Lime Down

Solar Park

Statement of Common Ground with Natural England (Tracked)

Document Reference: EXAM/8.4

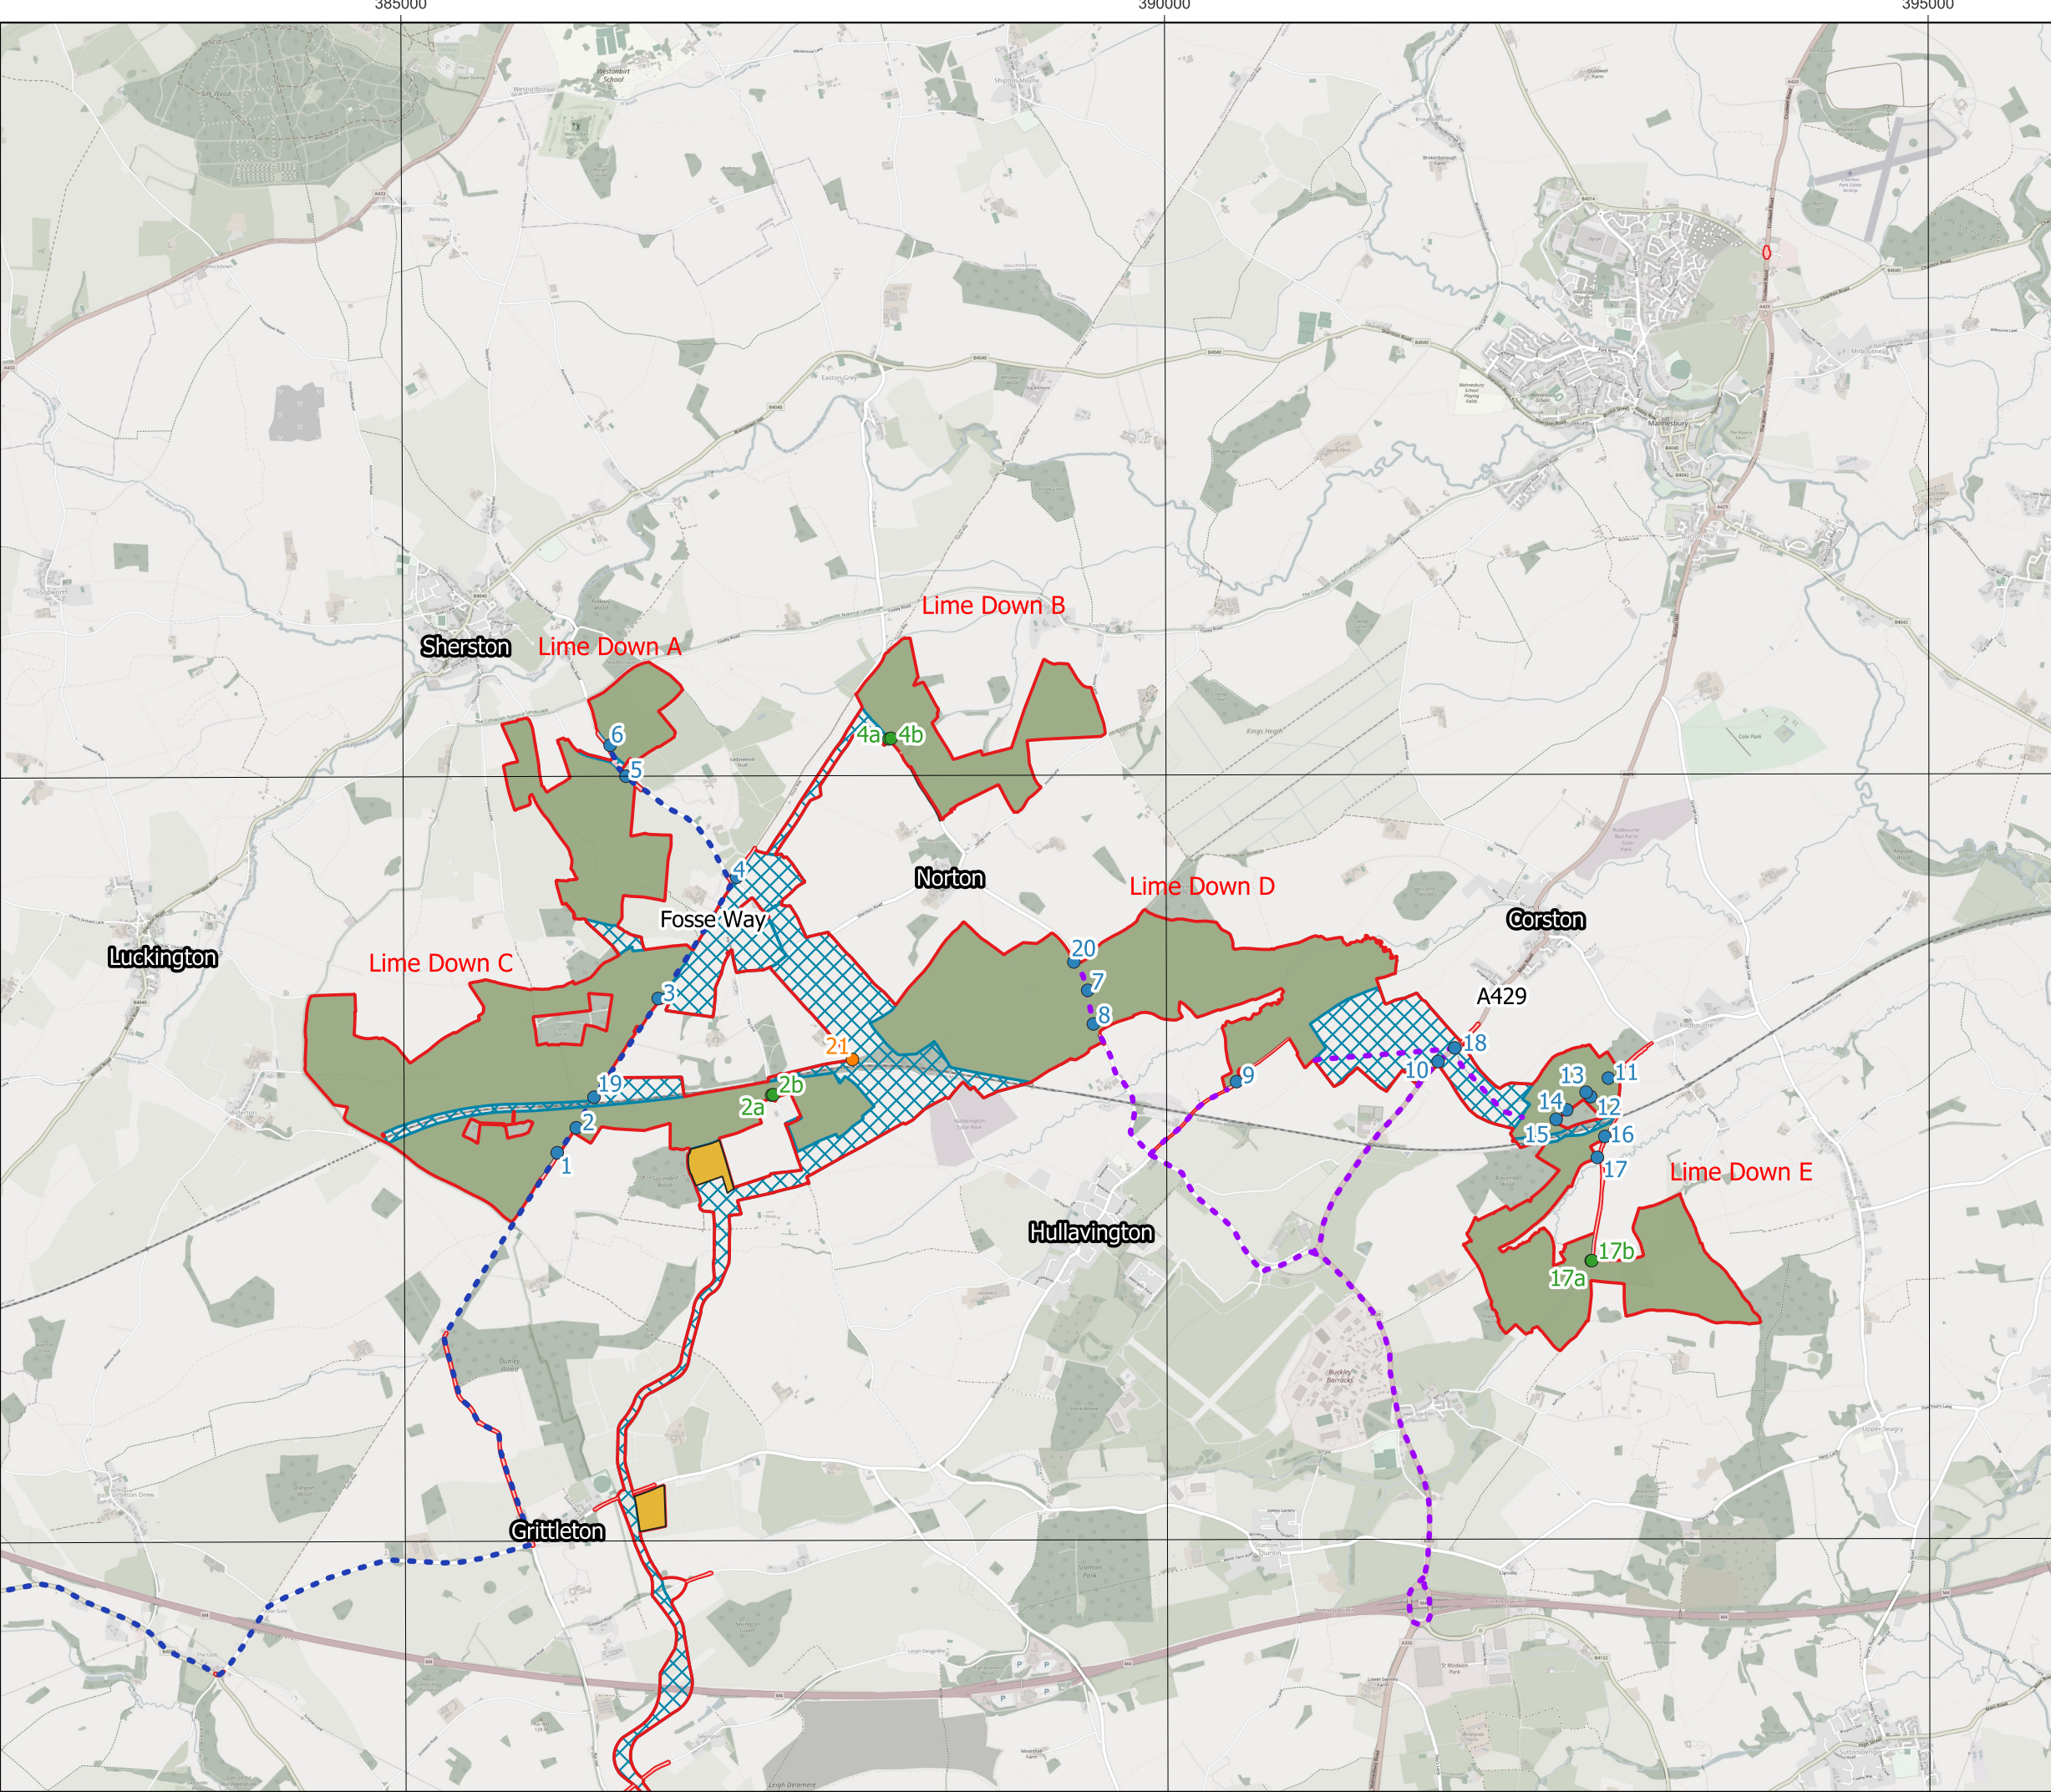
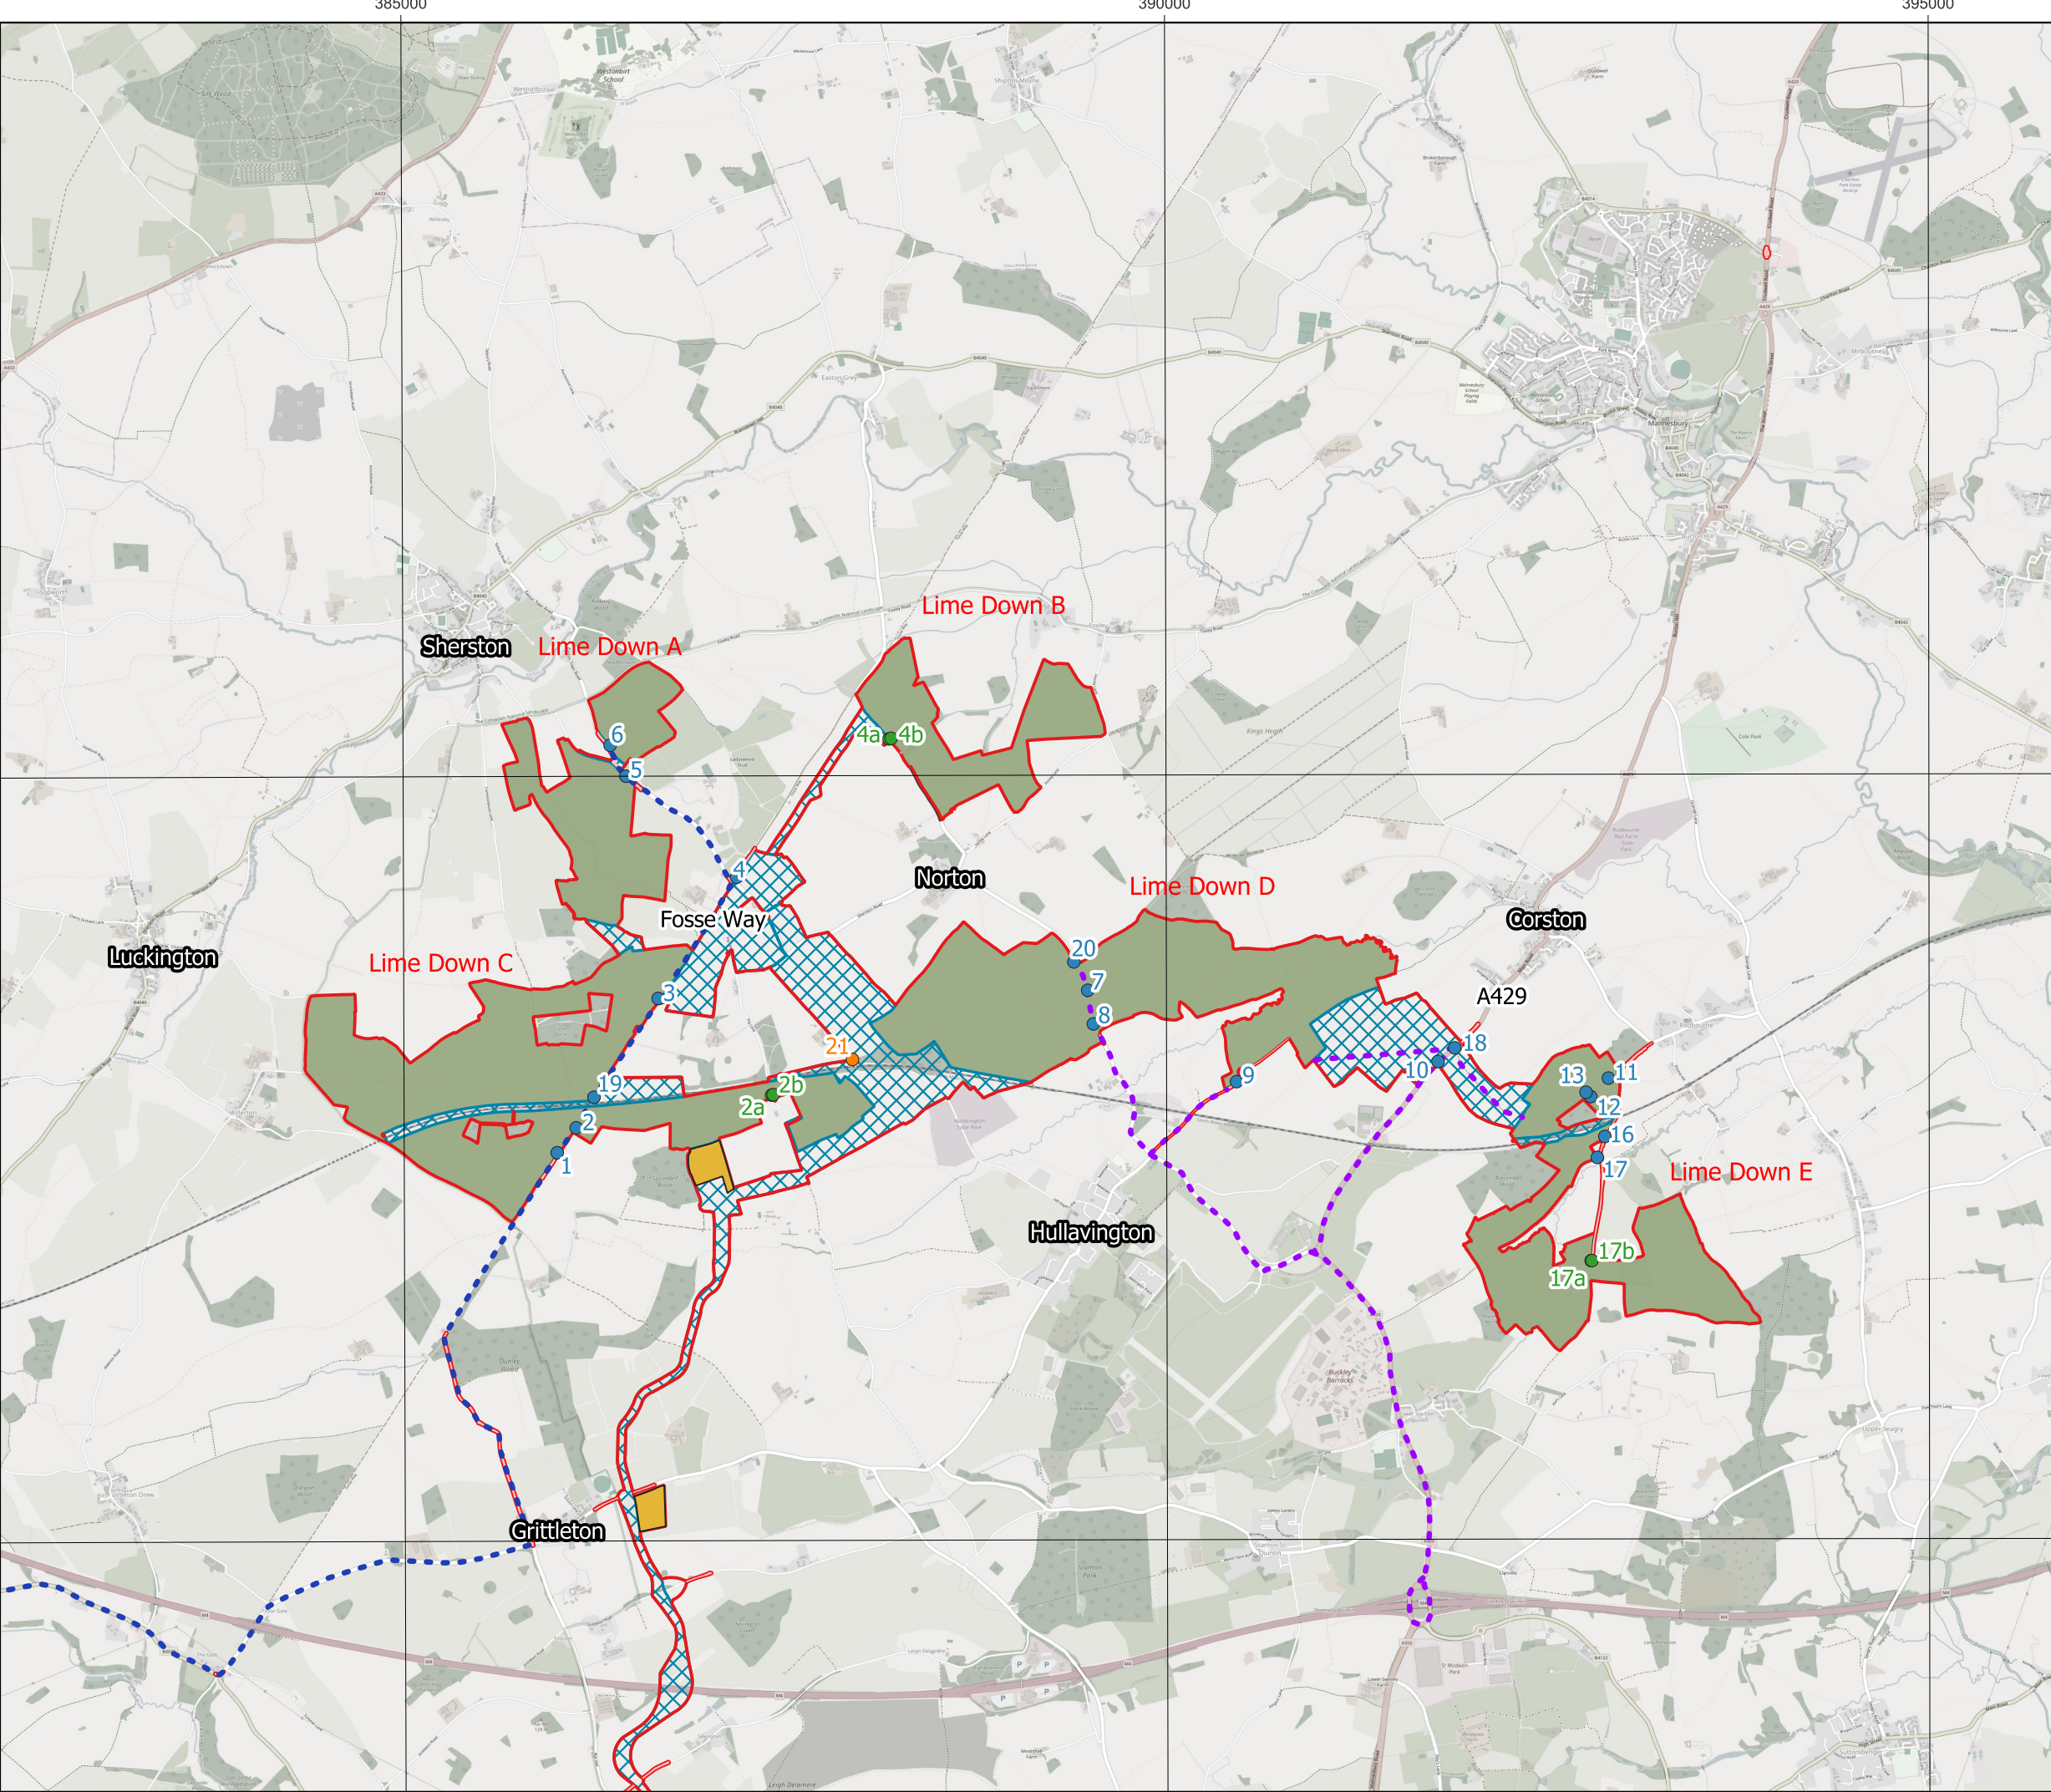
Reference	Sub-topic	NE Position	Applicants Position	Status
		designated sites, and confirms that Salisbury Plain SPA can be scoped out. For the Bath and Bradford on Avon Bats SAC, Natural England agrees that the solar PV site itself is not functionally linked land for greater horseshoe bats. However, the cable route corridor lies within an impact zone and could be functionally linked, meaning likely significant effects cannot be ruled out due to potential loss or fragmentation of commuting habitat. Impacts relating to loss of roosts, killing, or injury of greater horseshoe bats can be screened out. In relation to lesser horseshoe bats, while the HRA concludes the solar PV sites are not functionally linked, Natural England notes survey evidence showing regular early-night activity at Lime Down C, suggesting nearby roosting and potential functional linkage to the SAC. Although loss of foraging habitat is unlikely to result in significant effects, potential	Habitat Regulations Assessment Report [EN010168/APP/7.10 (Rev 2)REP3-090] will be prepared accordingly and submitted at Deadline 3. Natural England and the Applicant have reached agreement on the mitigation measures which would need to be included within Lime Down C to ensure that significant impacts to SAC lesser horseshoe bats resulting from fragmentation could be avoided. These measures comprise: Retention of hedgerows across Lime Down C with any required new gaps in hedgerows to be limited to a maximum of 10m (it is understood that a majority will be limited to 3.5 – 6m) with the exception of one larger gap of 12 – 14m for the proposed access off the Fosse Way.

Reference	Sub-topic	NE Position	Applicants Position	Status
		fragmentation of commuting routes within Lime Down C should be screened in for Appropriate Assessment. For Bechstein's bats, Natural England agrees that likely significant effects from loss or change to functionally linked land can be screened out due to distance, lack of suitable habitat, and absence of records. Evidence to date does not indicate functional linkage to the SAC, and impacts related to fragmentation, roost loss, or killing and injury are considered unlikely. Updated Position It is agreed that a vast majority of the habitat within Lime Down C provides suboptimal foraging habitat for lesser horseshoe bats. It is noted that the design of the proposed development has retained a majority of the hedgerows within Lime Down C and that losses have been minimised. However, due to the reasoning stated in the <i>Habitats</i>	b. Construction Lighting will be controlled to prevent light spill onto suitable commuting habitats. The Outline Ecological Protection and Mitigation Strategy (EPMS) [REP1-106REP3-102] details how sections of hedgerow to be permanently removed for new internal access tracks where no existing gap is present will typically be between 3.5 m to 6 m wide, with a maximum of 10 m of hedgerow to be removed in any one location for this element of the Scheme. It also details how sections of hedgerow to be removed to provide access from the existing highway network, including for Abnormal Indivisible Loads (AIL) will require a maximum of 18 m of hedgerow loss at any one access point, although would typically be less than this at most access points. At Lime Down C one AIL Location is expected to comprise a gap of 12 – 14 m in width, at Solar PV Access Location 19 (ES Volume 2, Figure 13-11 Construction Access

Reference	Sub-topic	NE Position	Applicants Position	Status
		<i>Regulations Assessment Report</i>, we agree that likely significant effects on the Bath and Bradford on Avon Bats SAC as a result of loss of foraging habitat cannot be screened out. Further, whilst a majority of the hedgerows in Lime Down C have been retained, it is noted that hedgerow gaps will need to be created in a number of areas to facilitate access. Further, uncontrolled artificial lighting could impede lesser horseshoe commuting activity across the site. Therefore, due to the reasoning stated in the <i>Habitats Regulations Assessment Report</i>, we agree that likely significant effects on the Bath and Bradford on Avon Bats SAC as a result of fragmentation cannot be screened out. Mitigation measures for loss of foraging habitat include the establishment of 15m buffer zones to all hedgerows and woodland across the Solar PV site. Further, it is noted that habitat creation and enhancement works will	Locations: Solar PV Sites [APP-156] refers). Appropriate limitations and controls for the use of artificial lighting during construction, designed to avoid impacts on bats and other light-sensitive species are detailed within the Outline EPMS [REP1-106REP3-102] as well as the Outline Construction Environmental Management Plan (CEMP) [REP1-096REP3-092]. Measures set out within the Outline EPMS [REP1-106REP3-102] and the Outline CEMP [REP1-096REP3-092] are secured by Requirements 8 and 13 respectively within the Draft Development Consent Order [REP1-007REP3-005]. On 3 June 2026 the Applicant provided NE with an advanced copy of the revised Habitat Regulations Assessment Report [EN010168/APP/7.10 (Rev 2)]REP3-090 to be submitted at Deadline 3. On
